**Application no: 21/02376/DISC**

**Location:** E P Barrus Ltd, Launton Road, Bicester, OX26 4UR

## **Transport Development Control**

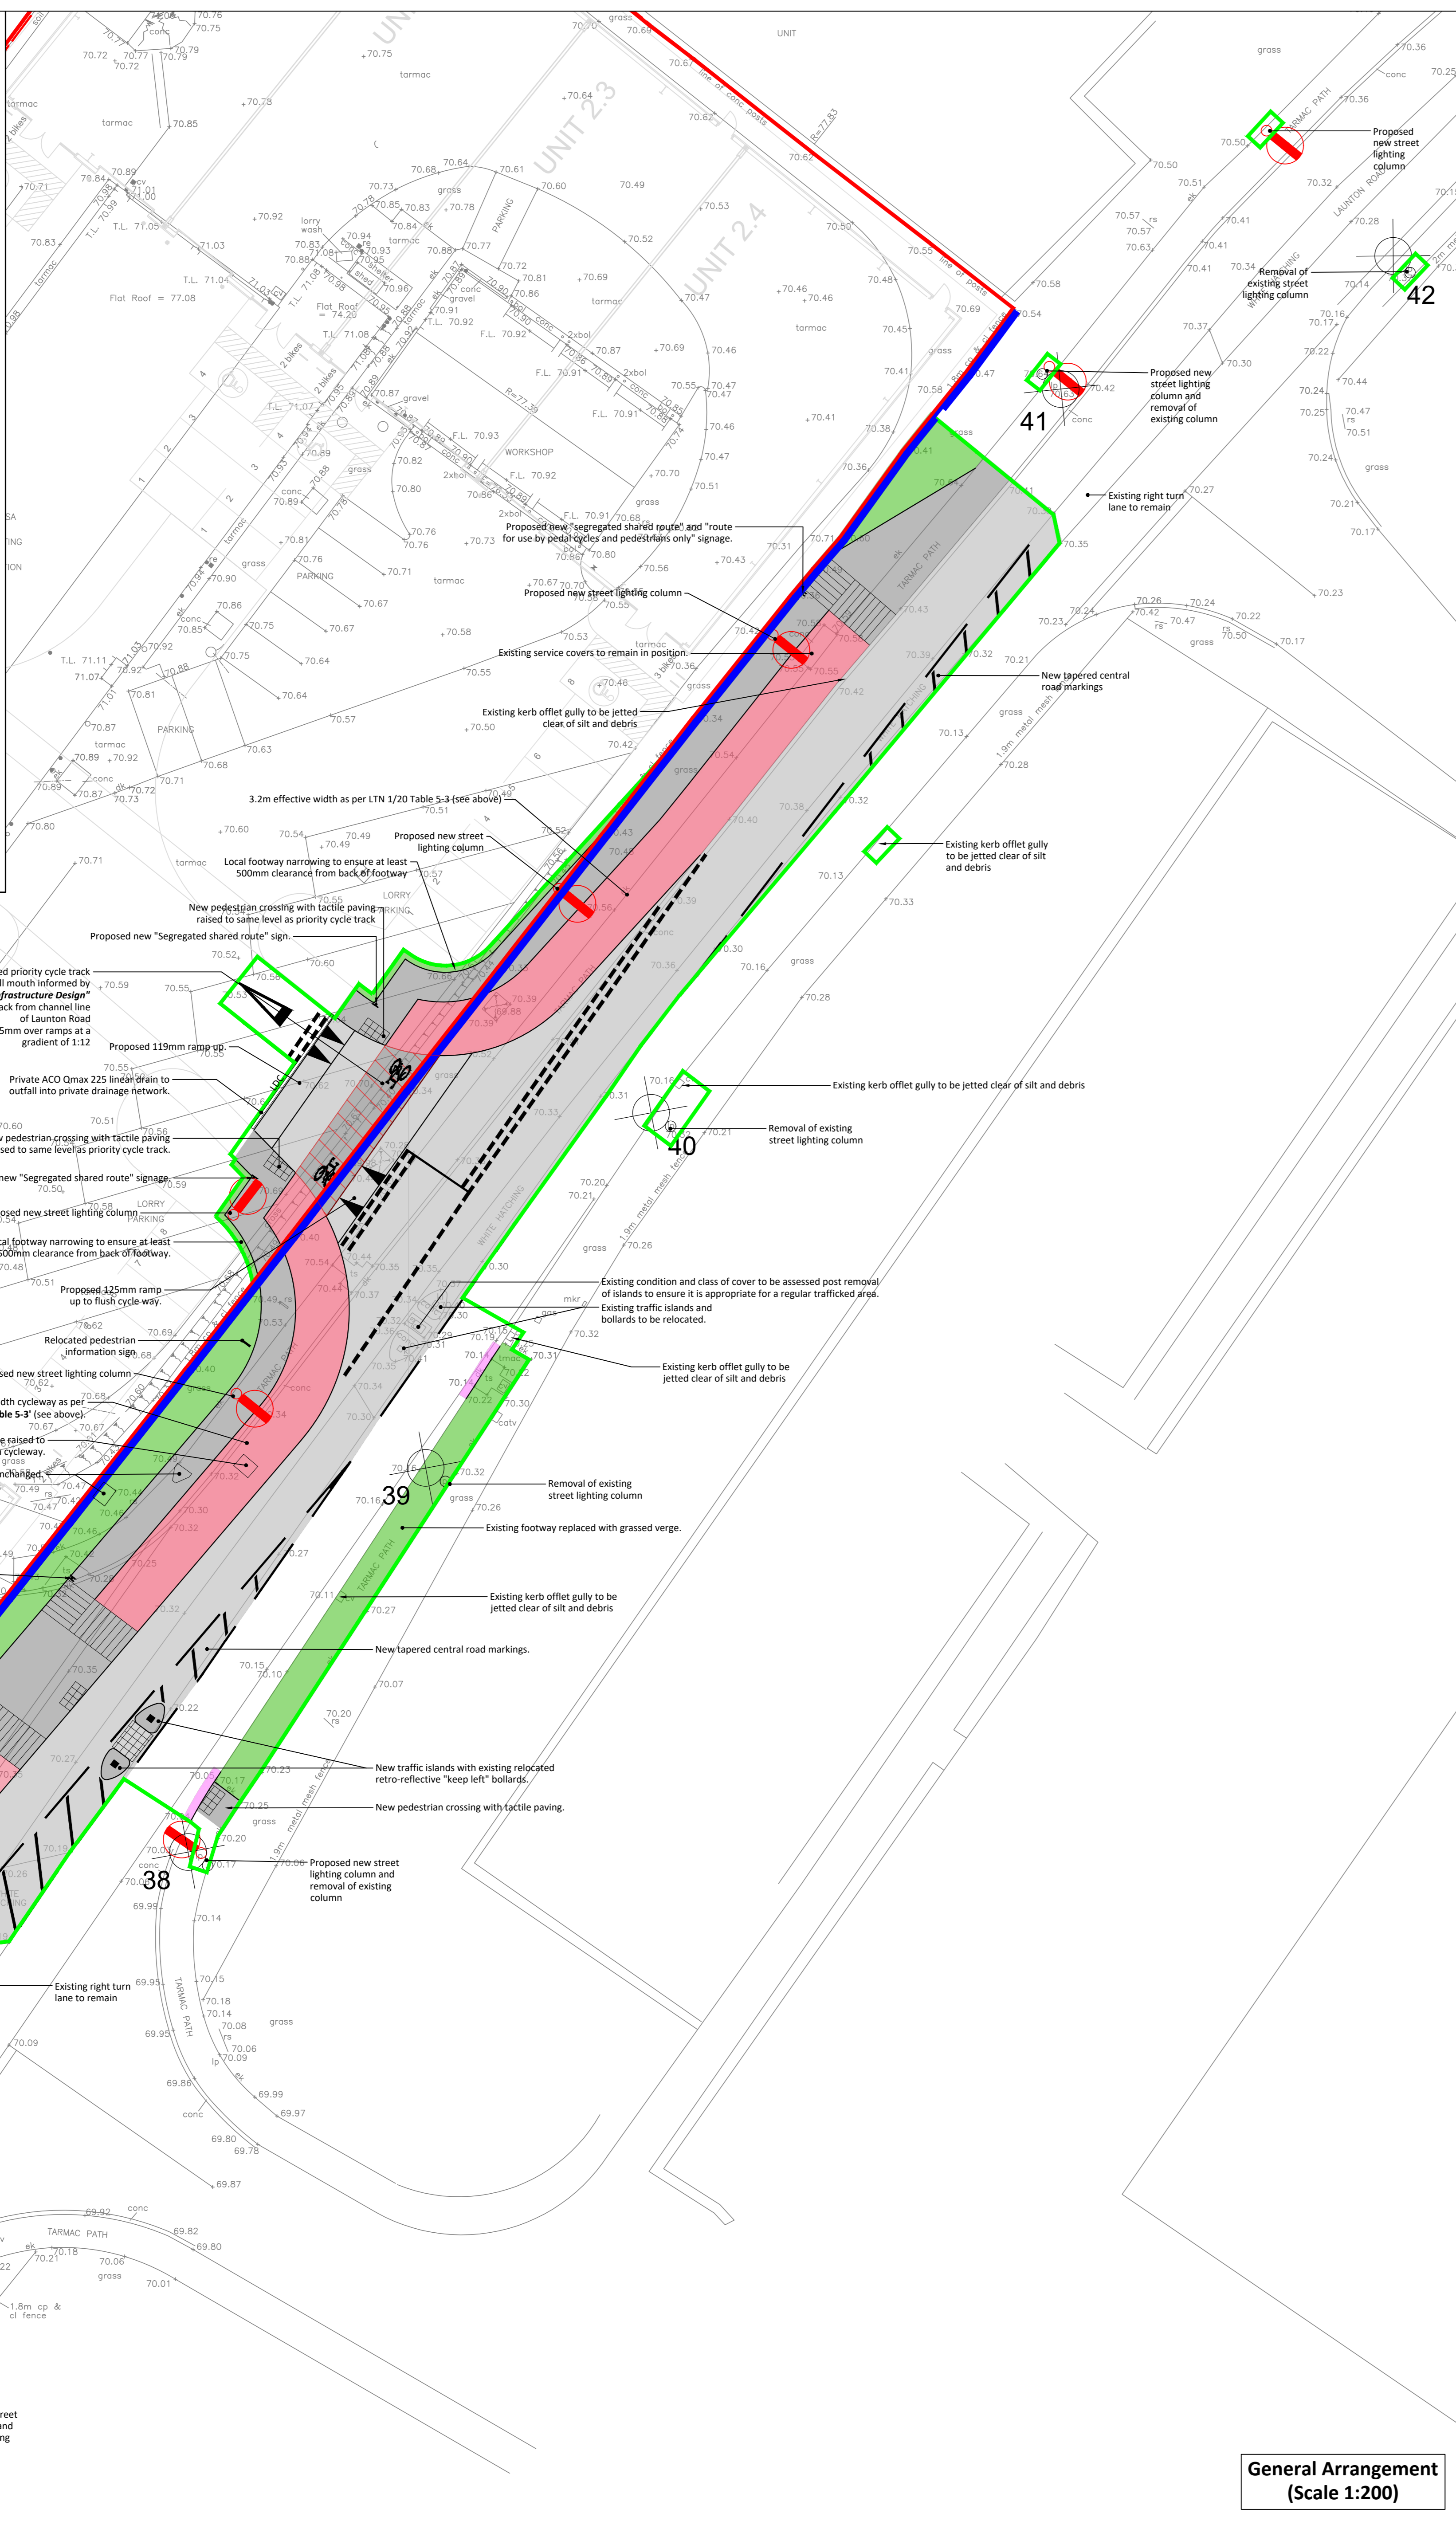
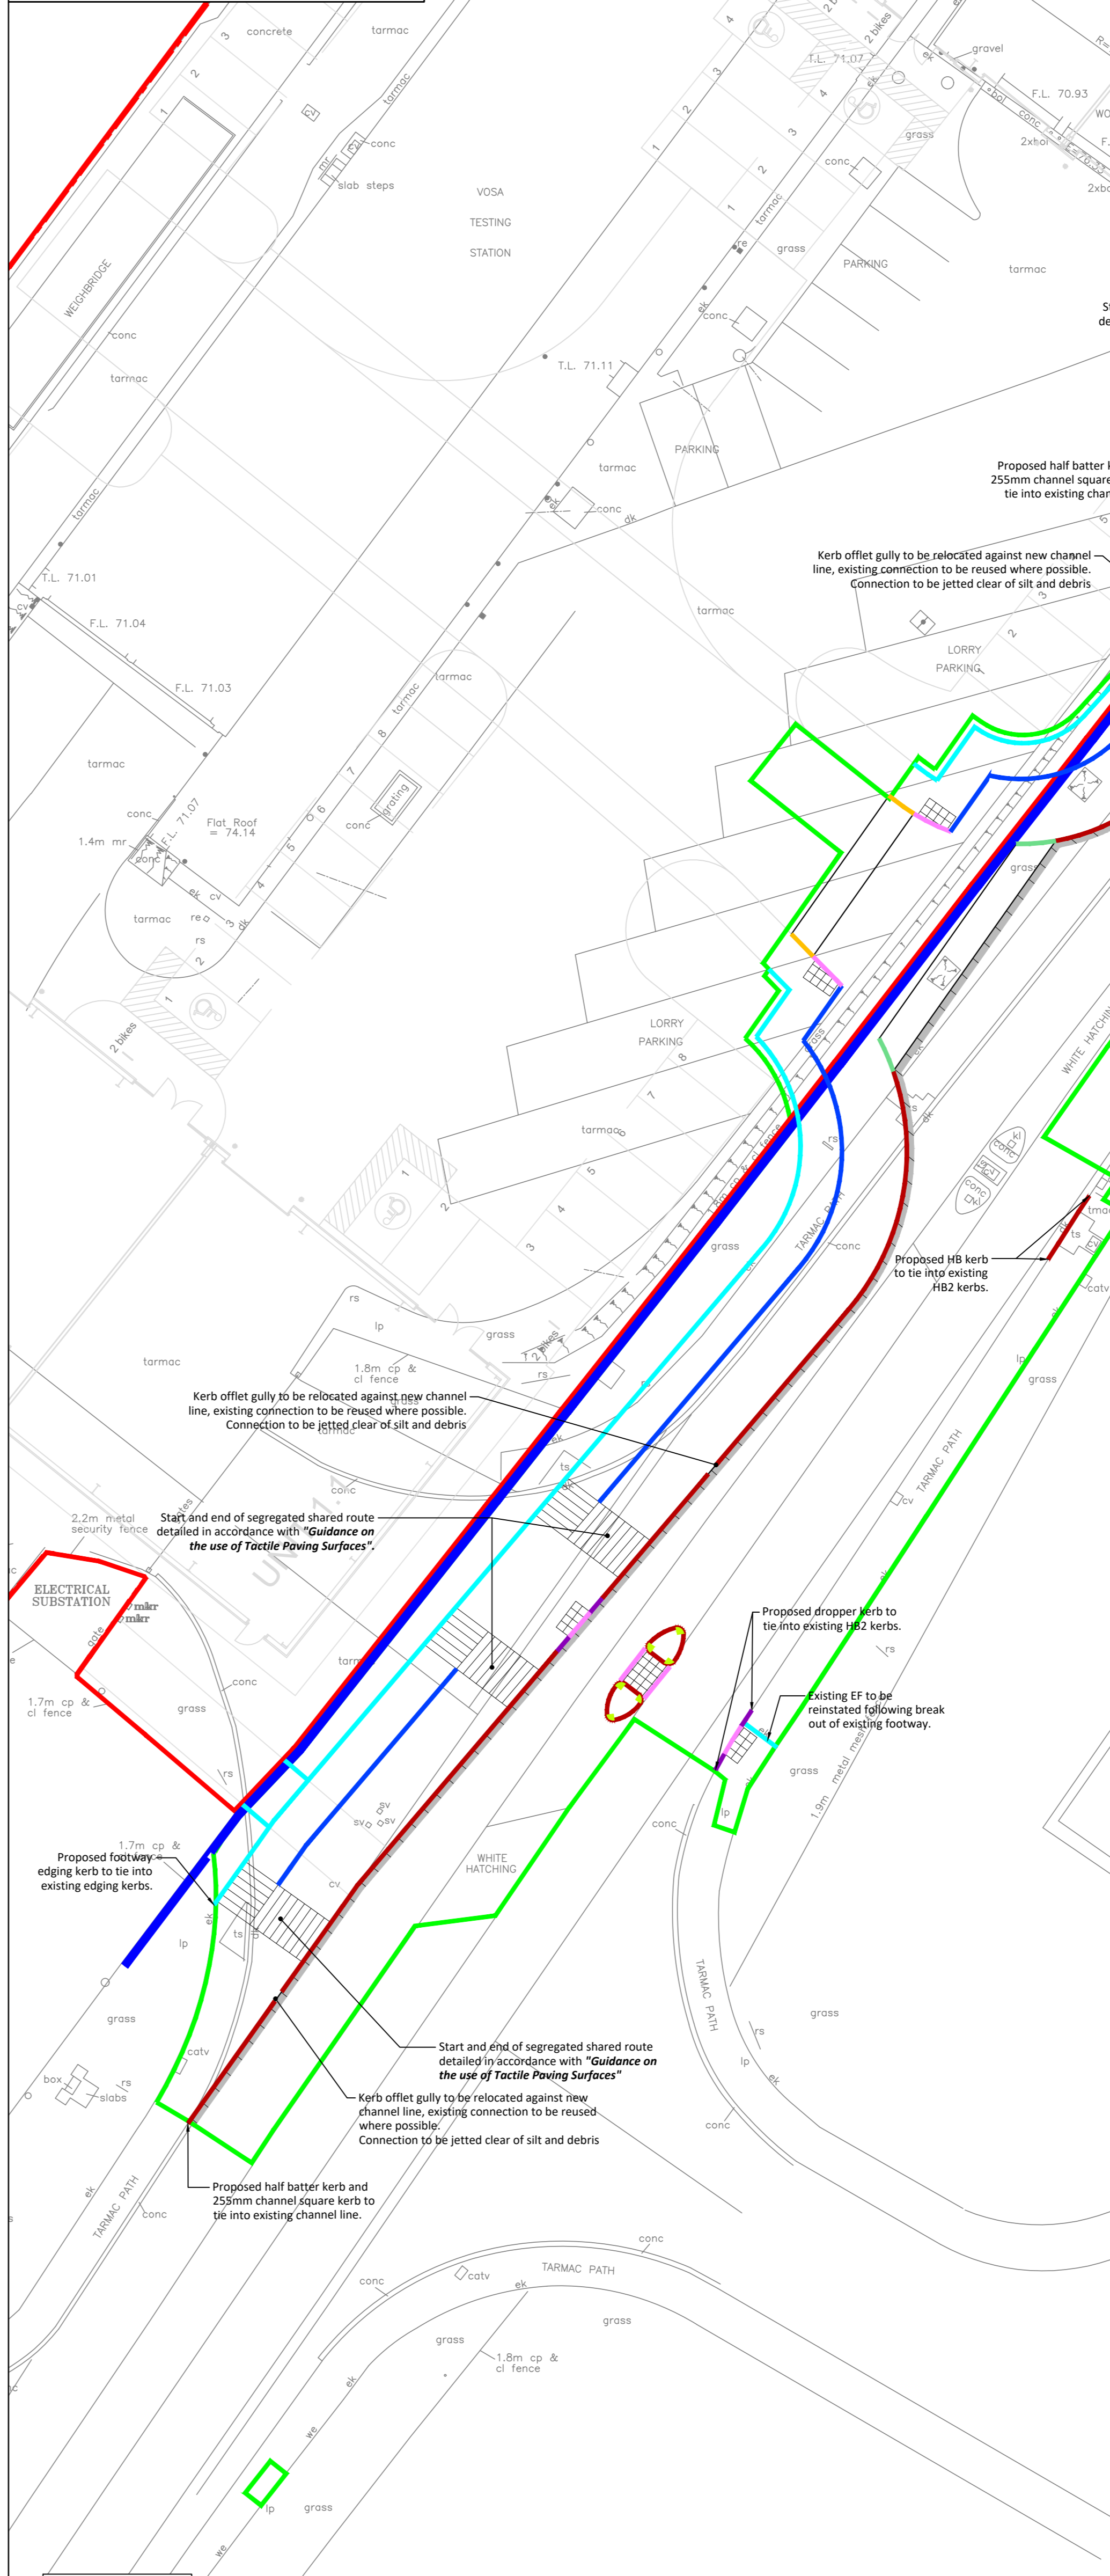
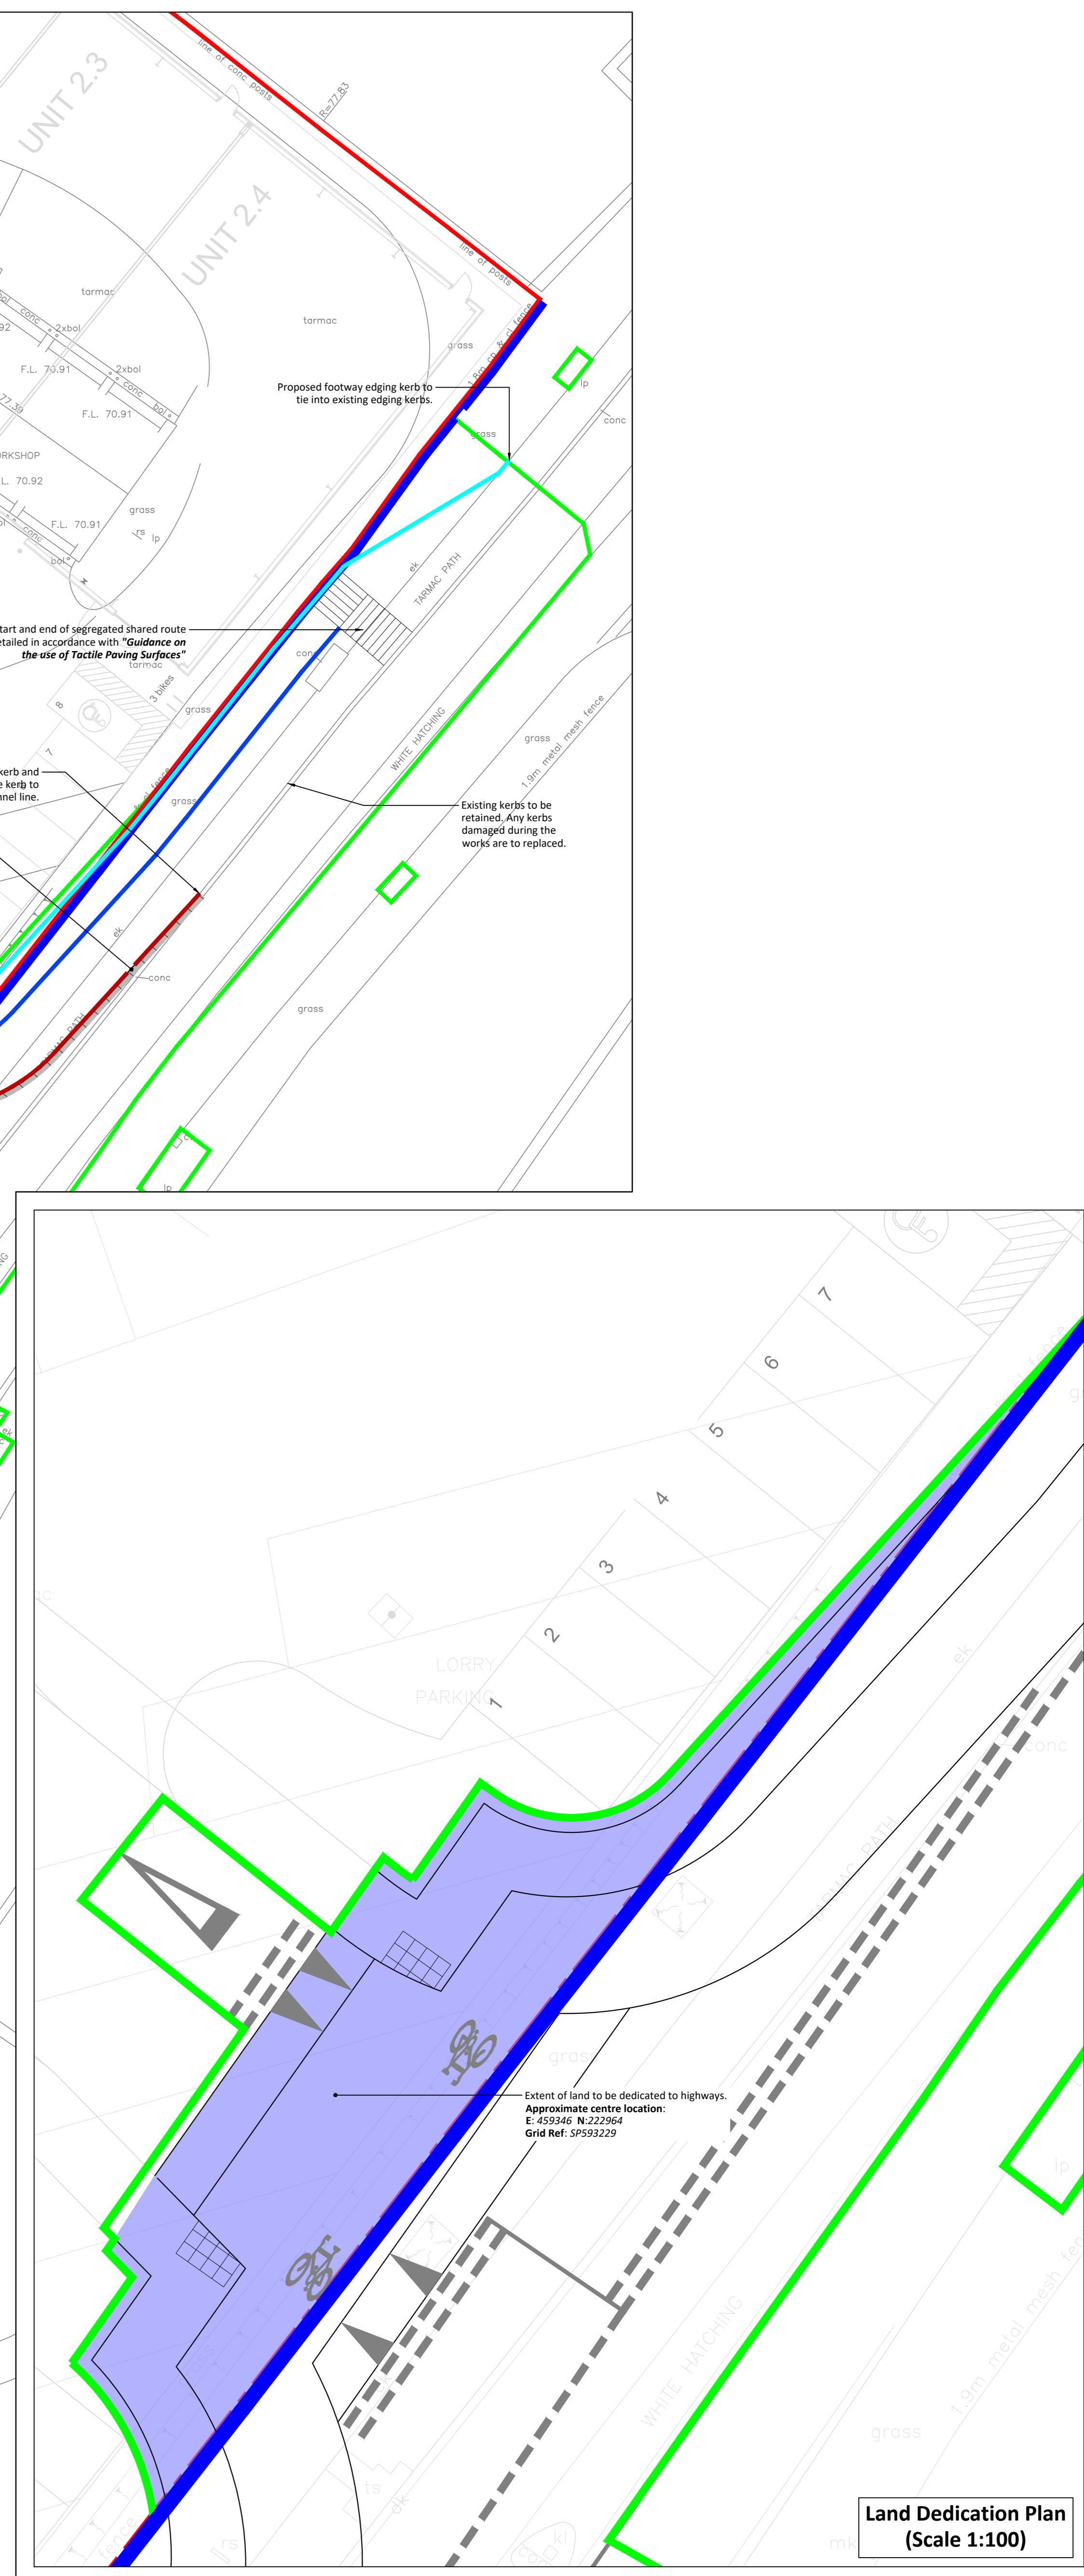
Condition 4 - In our initial response to application no. 20/02139/F, we requested that a partially or fully set back cycle priority crossing be provided at the new site access. This has not been delivered in the submitted documents for this application. Detailed guidance on this type of crossing can be found in section 10.5 of LTN1/20, in figs 10.14/10.15 and 10.16. The request for the priority cycle crossing was included in our response to CDC where we outlined our section 278 requirements.

The delivery of the priority cycle crossing is viewed as essential to the acceptability of the site, hence the references to the Bicester LCWIP and LTN1/20 in condition 4 of the decision notice. Launton Road is identified within the LCWIP as a Category C 'high traffic route' which means that it has been identified as a vital radial 'quickway' cycle route into and out of Bicester town centre. Launton Road is one of the three roads in Bicester which accounted for 60% of all cyclist casualties over the last 5 years. Providing safe crossing facilities for cyclists on roads frequently used by HGVs is essential.
